Your reference:  
Our reference: PART 3A DOC12/49090;  
LIC08/957-05  
Contact: Karen Marler (02) 4908 6803

17 DEC 2012

**DA 376-8-2003 MOD5, Bulga Underground - Modification 5 - Blakefield North Longwall Modification and Gas Fired Power Plant**

Figure 7-11: Scenario 1 predicted incremental 1-hour average NO₂ concentrations (µg/m³)

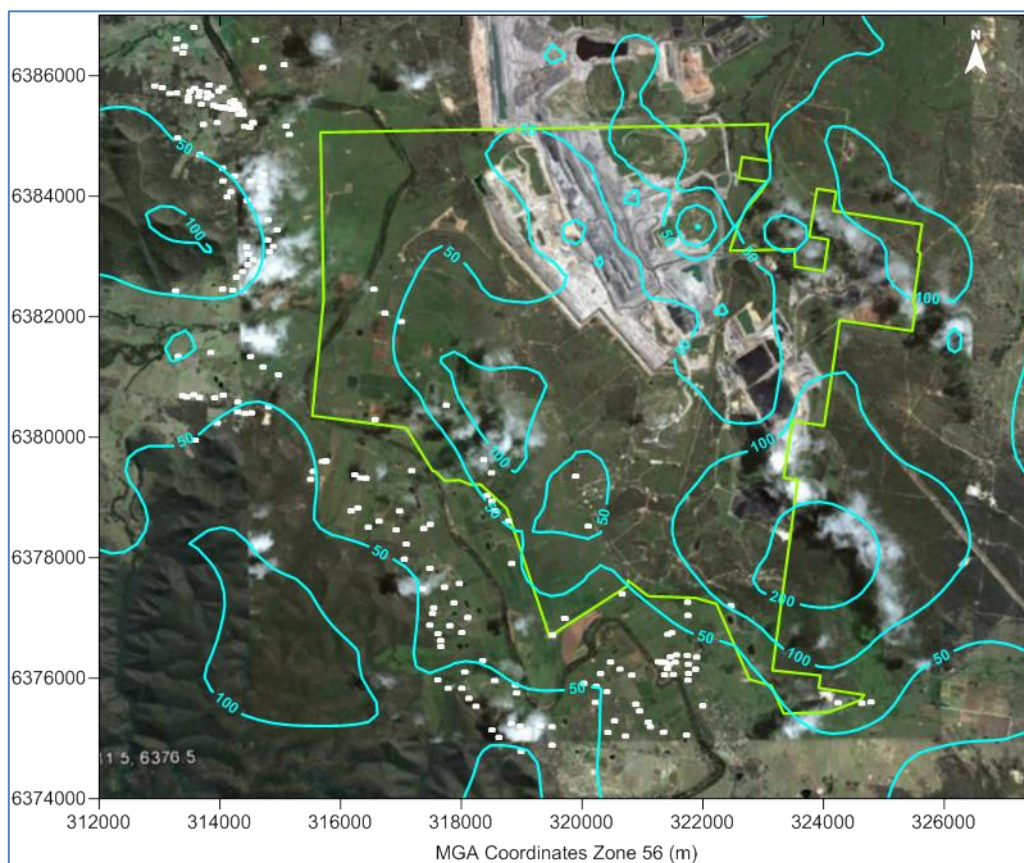
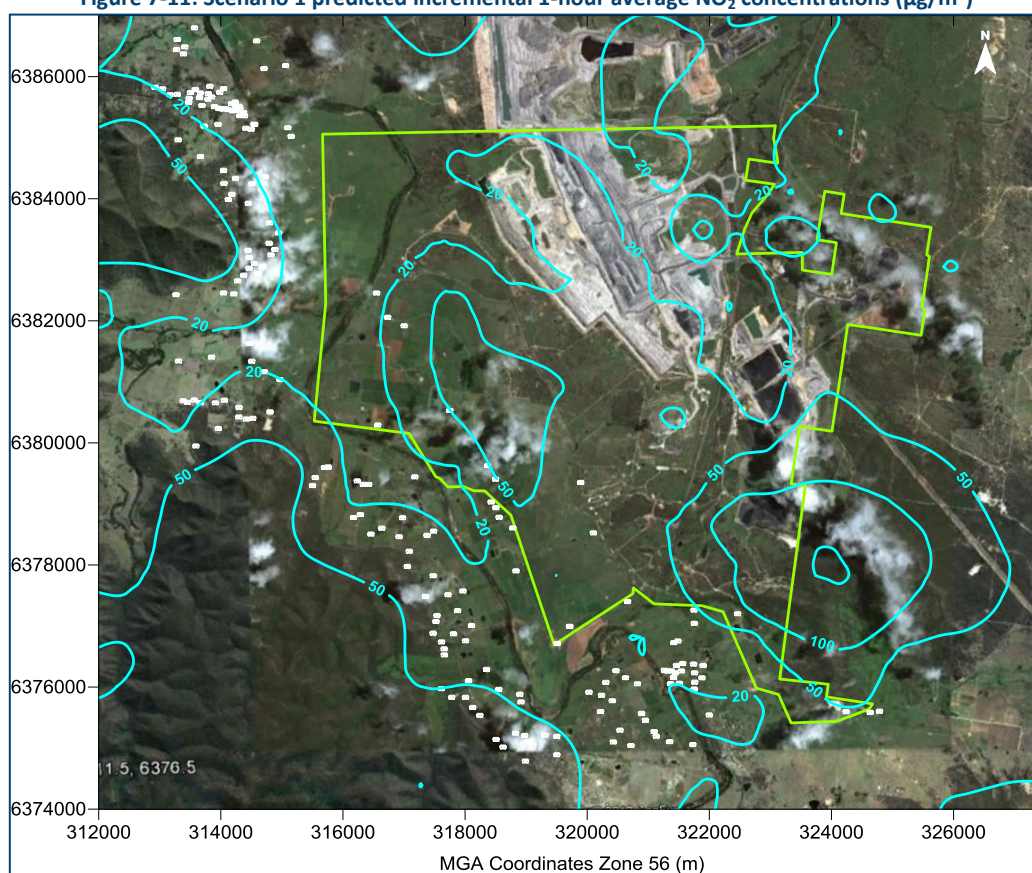
- 1. Emissions from the approved 25 MW of gas-fired power generation have not been included in the air impact assessment and the method of transformation from NO to NO<sub>2</sub> has not been specified.**

The maximum predicted 1-hour average nitrogen dioxide (NO<sub>2</sub>) concentration is 44% of the assessment criterion which is significant.

Despite the potential for the plant associated with the 25 MW of gas-fired electricity generation to be a significant nitrogen oxide (NO<sub>x</sub>) emission source, it is not included in the assessment of air emissions from Bulga Underground Operations and the project operations.

The EPA recommends the Air Quality Impact Assessment provided as part of the EA be revised to include all existing, approved and proposed nitrogen oxide emission sources.

The Air Quality Impact Assessment assumes NO<sub>x</sub> emissions comprise 20% NO<sub>2</sub> at the emission point. It is not clear what, if any, method was used to further assess the transformation of NO to NO<sub>2</sub> in the atmosphere, as required by the *Approved Methods for the Modelling and Assessment of Air Pollutants in New South Wales* (Approved Methods).

The EPA recommends the Air Quality Impact Assessment be revised to include further detail to clarify the method used to estimate NO<sub>2</sub> impacts. Specifically more detail is required on the method used in the assessment to model the oxidation of NO to NO<sub>2</sub>.

Figure 7-18: Maximum Cumulative Case predicted incremental 1-hour average NO₂ concentrations (µg/m³)

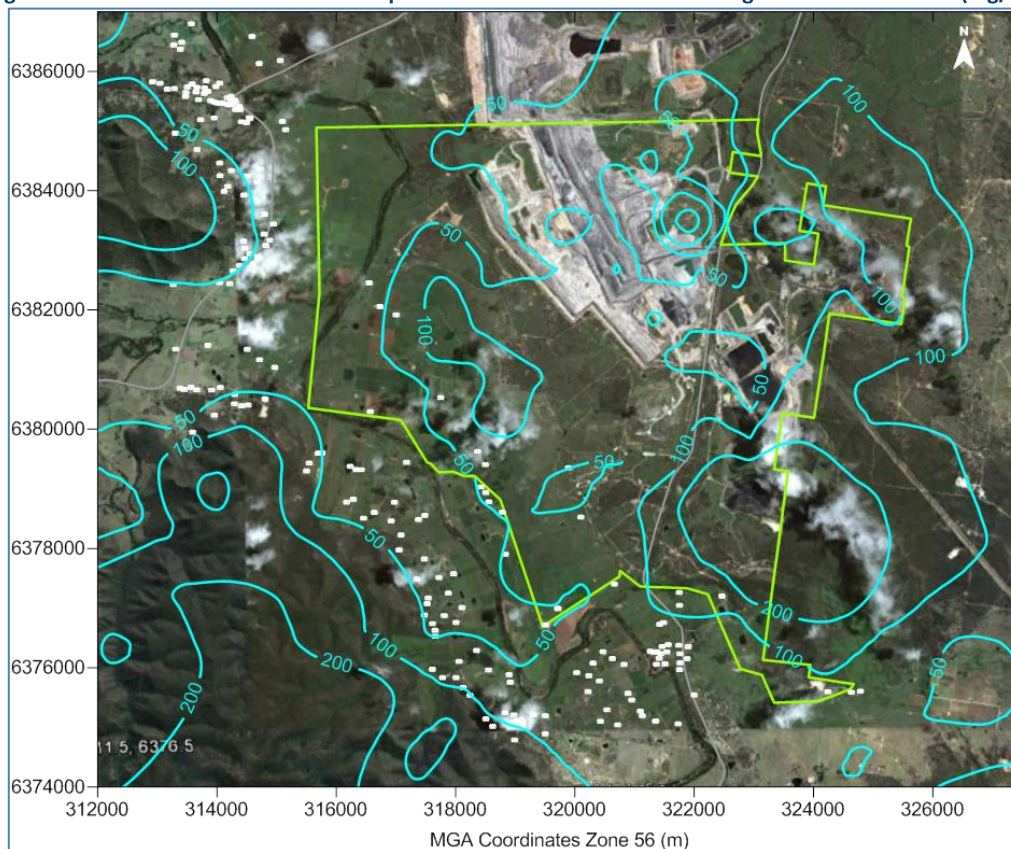
- 2. The worst case project dust emissions result in only a small increase in cumulative impacts, however cumulative 1-hour average NO<sub>2</sub> impacts are 57% of the assessment criteria**

The impact from project and background emissions combined is predicted to be 57% and 17% of the 1-hour and annual average NO<sub>2</sub> assessment criteria.
